MEMO

19 February 2009

11 DWELLINGS - STATION ROAD, ANGMERING – A/158/08

Proposed Site Layout @ 1:500

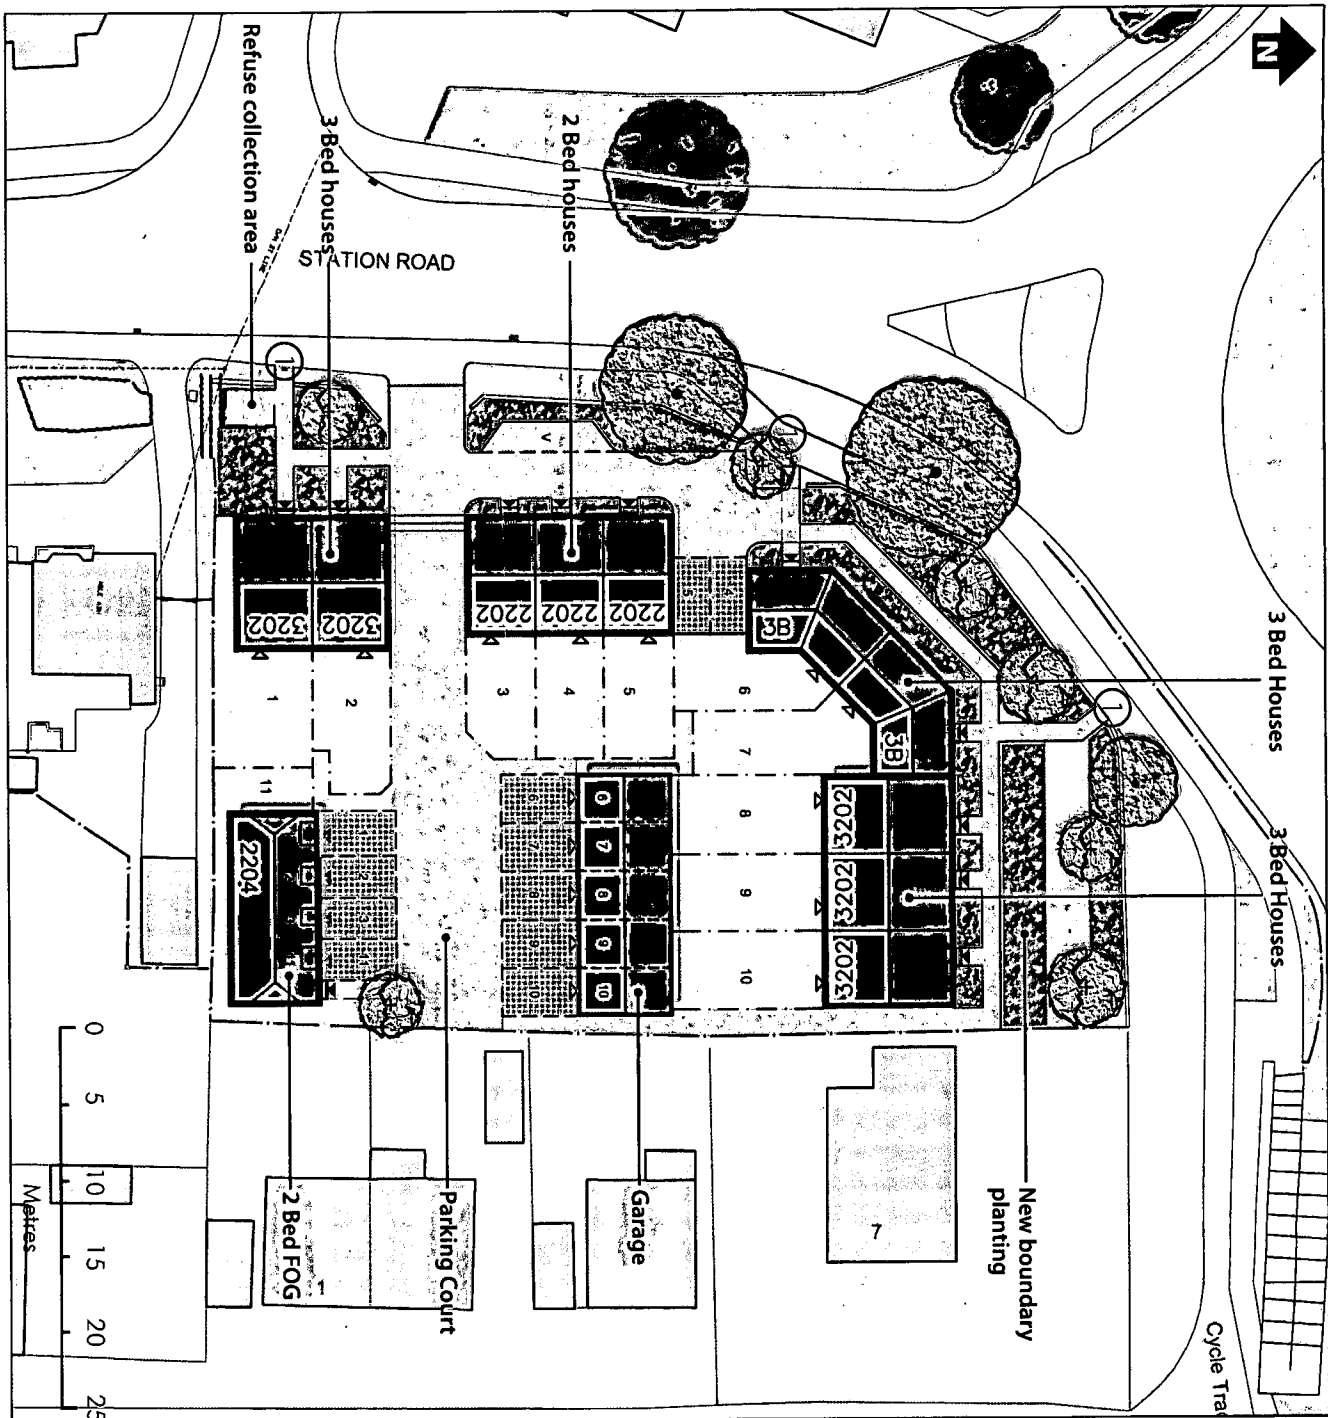
In accordance with the current SPG on open space and recreation standards a development of this size must provide public open space as part of the development. In the case of 11 houses an area of 633 m² would need to be provided.

There appears to be very little information on proposed landscaping. This is a key site on the entrance to the southern part of Angmering and East Preston adjacent to the A259. The opportunity to provide quality landscaping and screening in appropriate locations must not be missed and left to a condition with any planning permission.

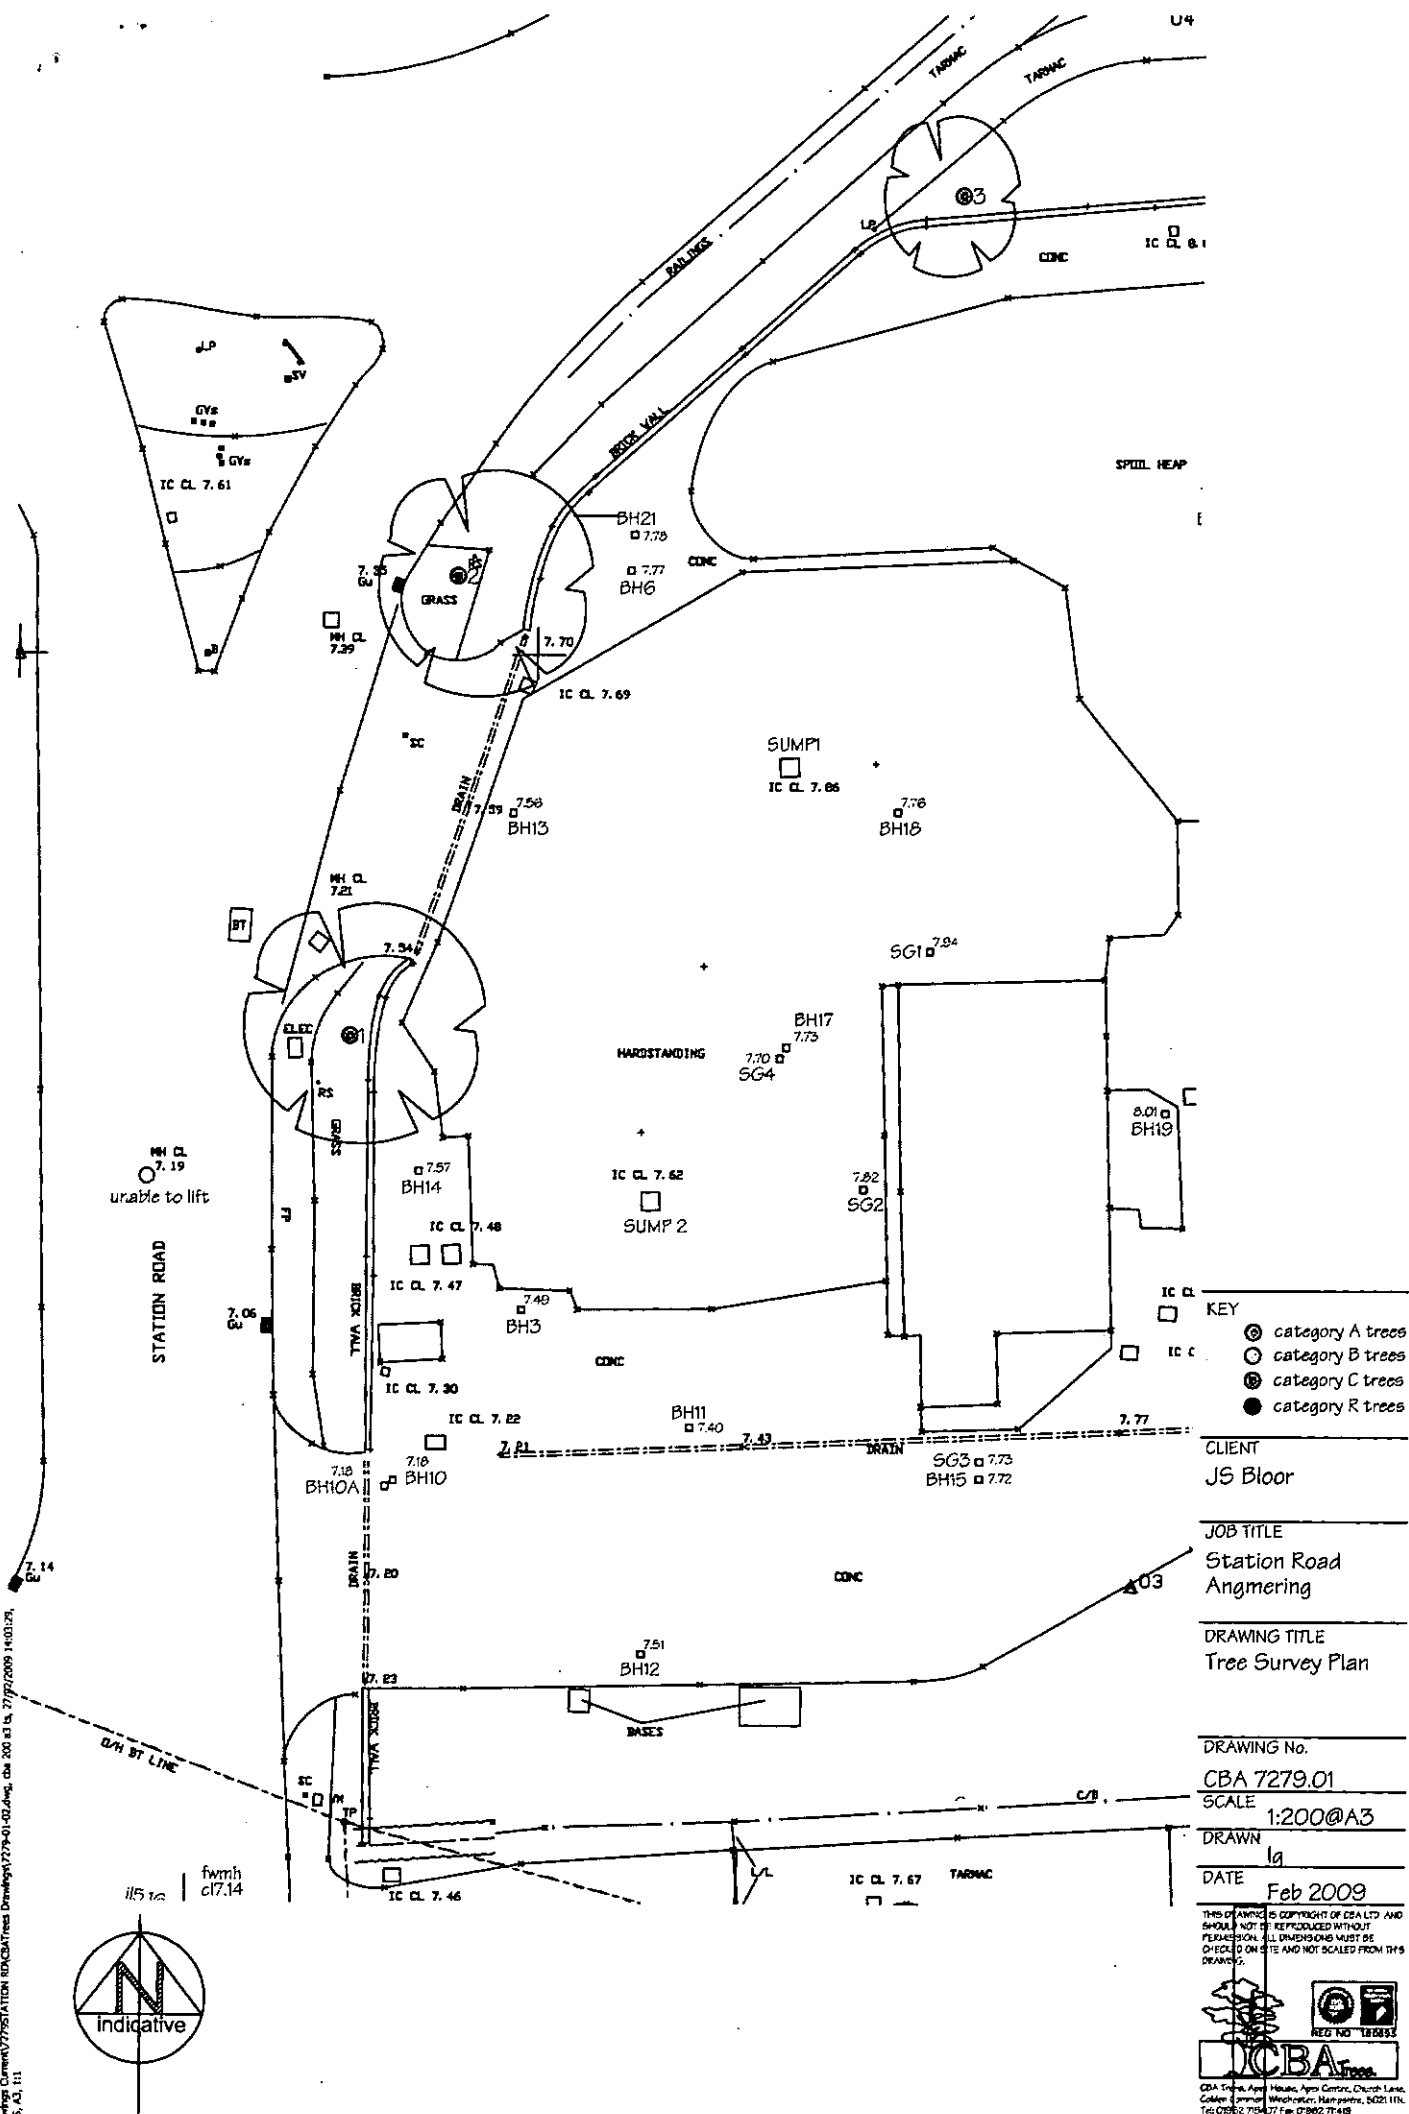
It is noted that several trees border the development and appear to be outside the red edge of the application site. However these trees likely to be the responsibility of West Sussex County Council may be affected by the development due to their proximity; their root system and therefore health may be affected. The application must provide information on how the development will allow for the satisfactory retention of these trees in accordance with BS 5837 Trees in relation to construction.
